From: Scott-Heagerty, Tom [REDACTED]
Sent: 25 August 2021 16:56
To: angela.marlow [REDACTED] Tom Day [REDACTED]
Cc: Seymour, James [REDACTED] Simon Davis <Simon.Davis@arun.gov.uk>; [REDACTED]
Subject: RE: Church Norton Spit planning application HRA

I am working on the HRA for the Pagham spit applications (ADC P/93/21/PL, CDC 21/01921/FULEIA). Looking at the March 2017 HRA, I am trying to ascertain quickly the main points of change between that application and this. The main points I have identified so far (the first four from Tom's consultation response of 12 August, the last two from talking to Robin Henderson and Dom Henly):

Drawing B

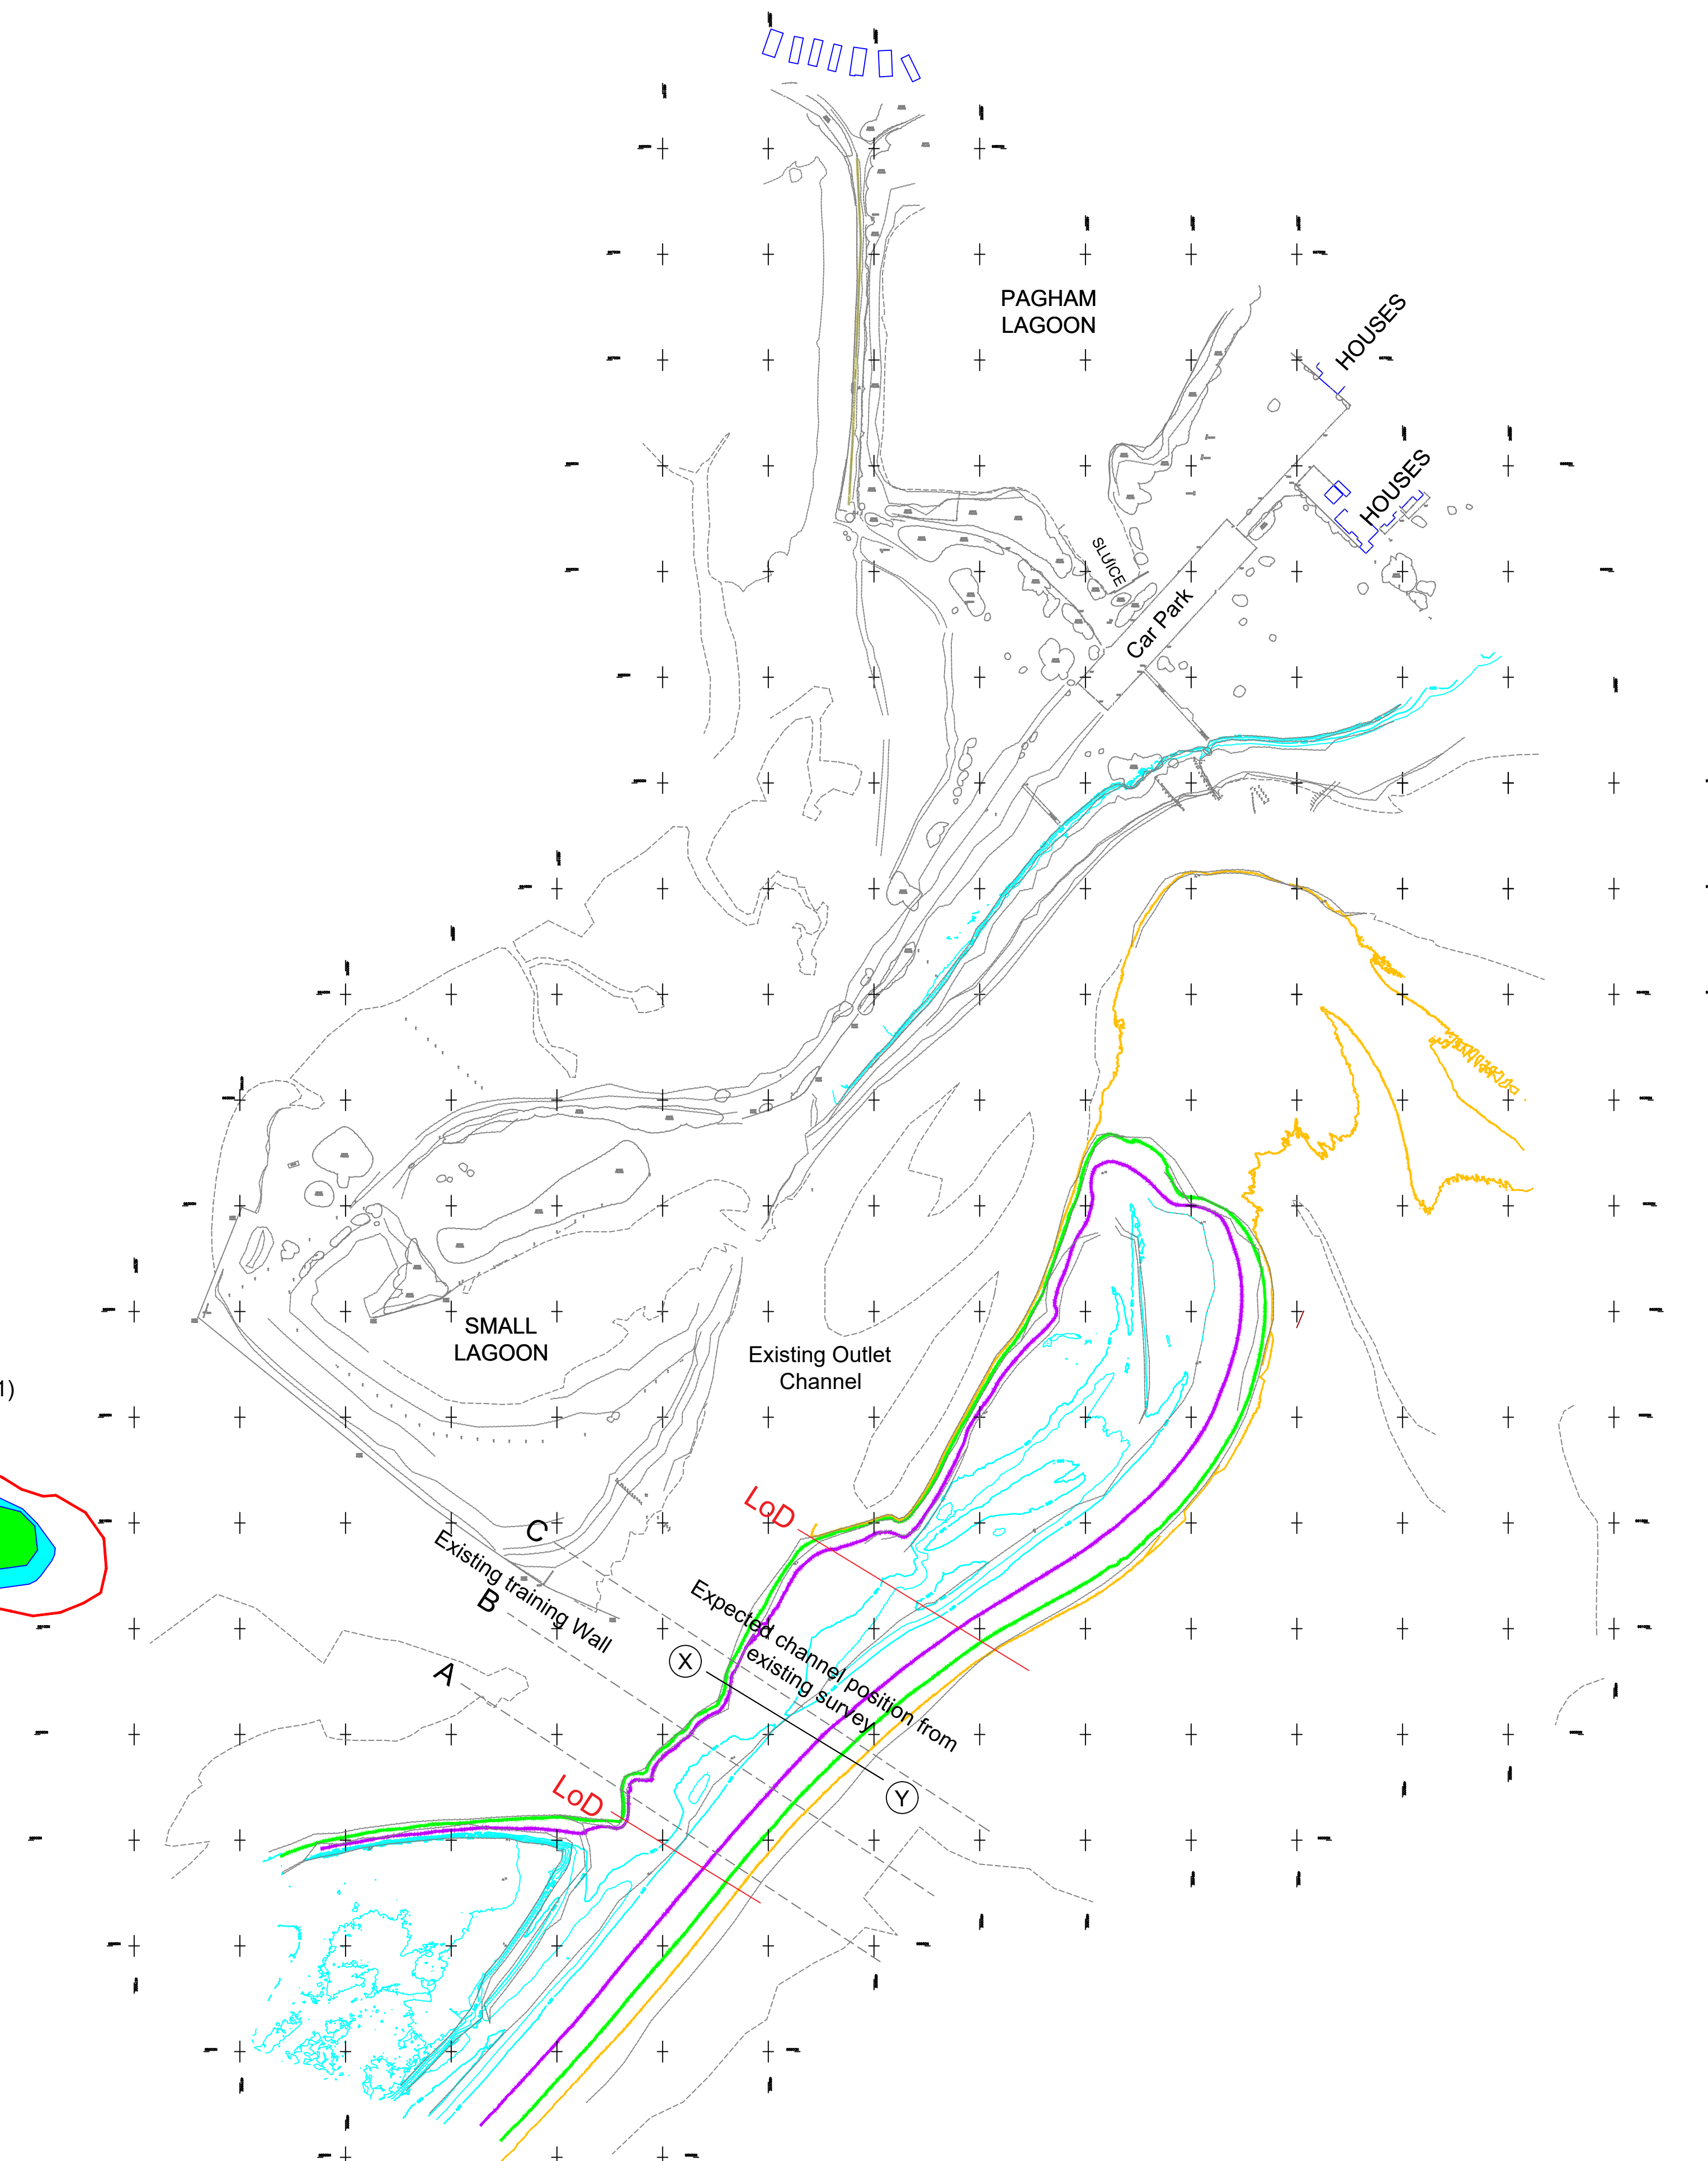
- Also, as a new location for the compensatory habitat has been proposed, this needs to be identified within the HRA as it is different to the original compensatory habitat included in the 2017 HRA.

- Natural England supports the new location for the compensatory tern island. However, we will still need reassurances that the compensatory habitat will remain suitable for the Little Tern population in the absence of nesting habitat on the Church Norton spit. Monitoring, management and possibly maintenance of the compensatory tern island should be considered, as we are concerned that the island could be exposed to additional erosion from the newly created channel. Reassurance on the likelihood of this and how this would be managed needs to set out.

Drawing A

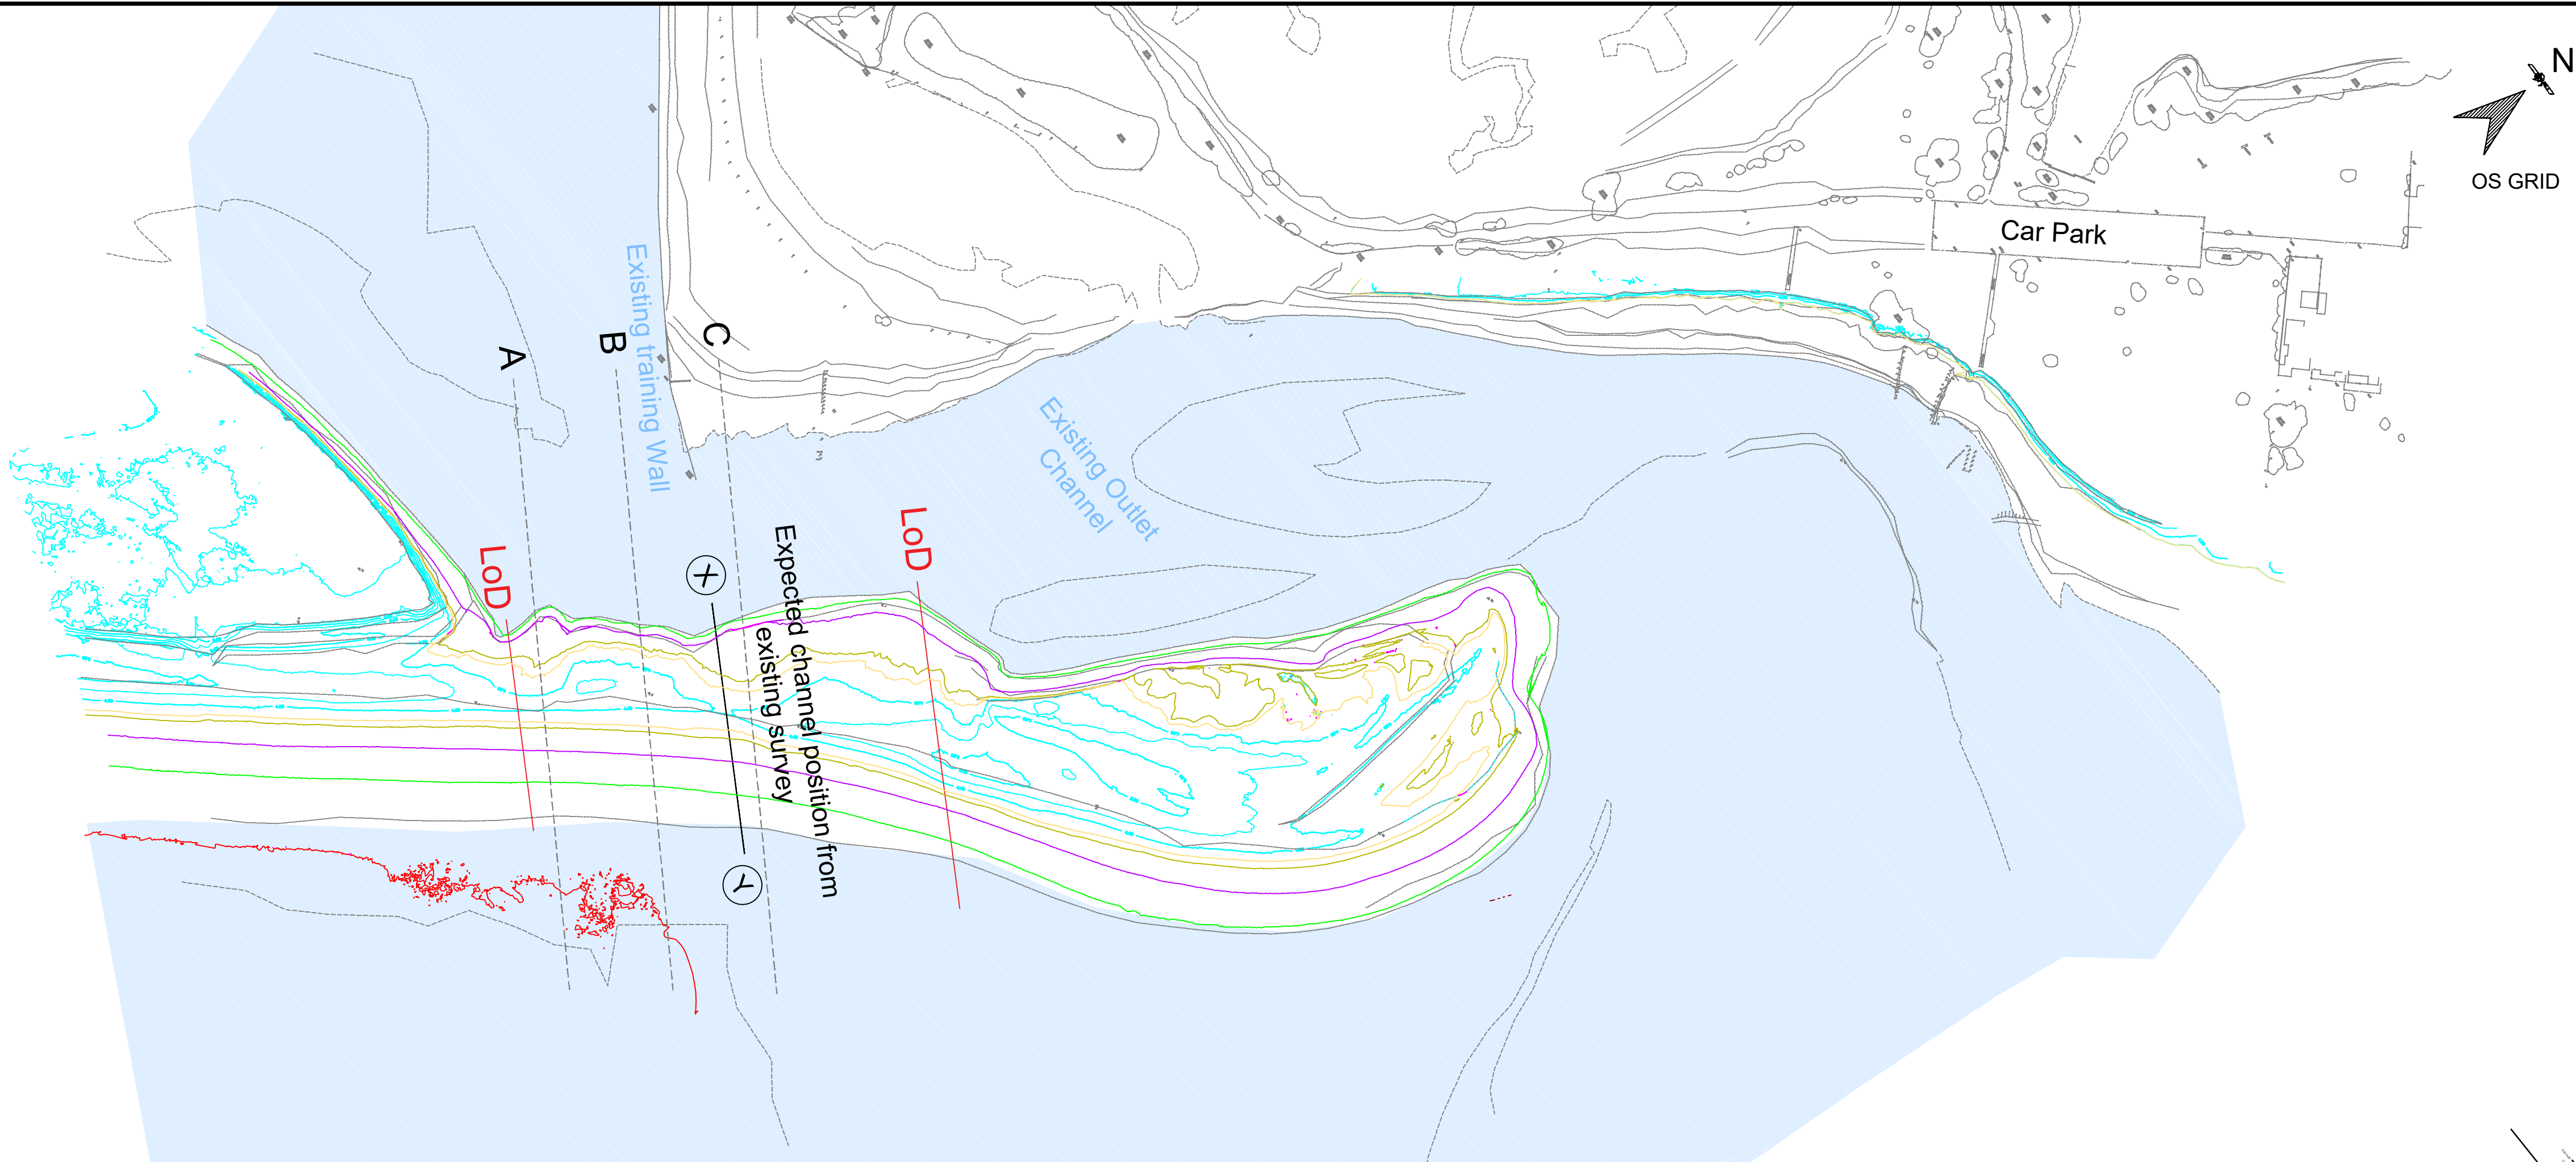
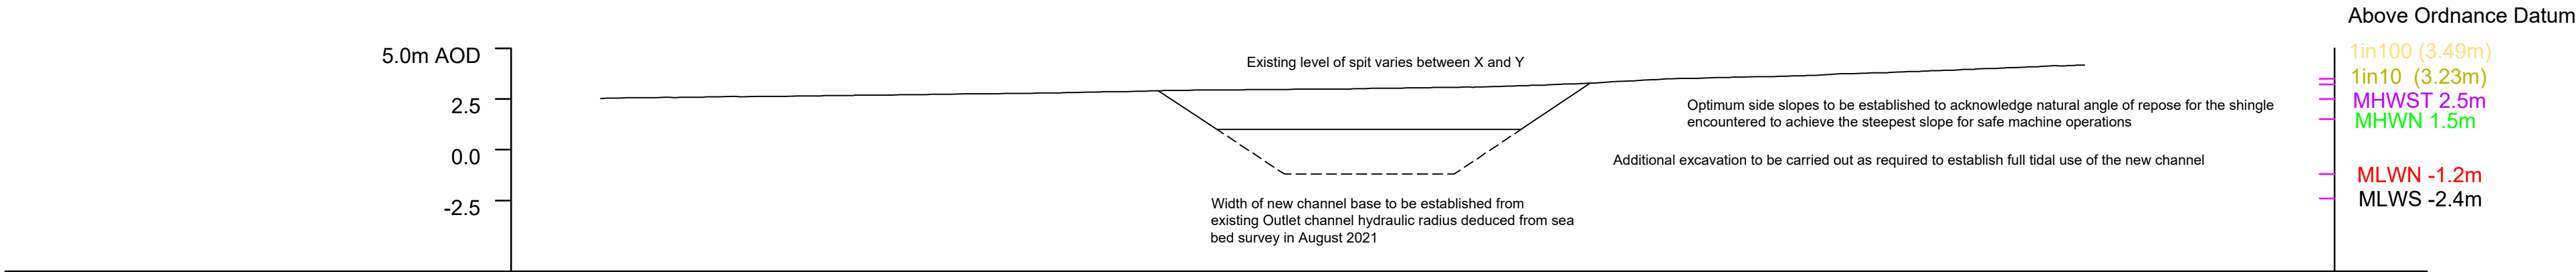
- The proposed location of the cut is directly through the current nesting area of the Little Tern population. The scale of works may be smaller, but will still result in direct loss of nesting habitat.

- Although the area of cut in the spit is smaller than the previous application. The cut will still result in the detachment and loss of the distal end of the spit, which is still a considerable area that is functional (foraging and nesting) for a number of bird features. Although the cut area may roll back and weld onto Pagham beach, it's functionality will be lost to the bird features of the sites, as there is greater recreational disturbance along the Pagham beach compared with the Church Norton spit, where terns cannot nest.
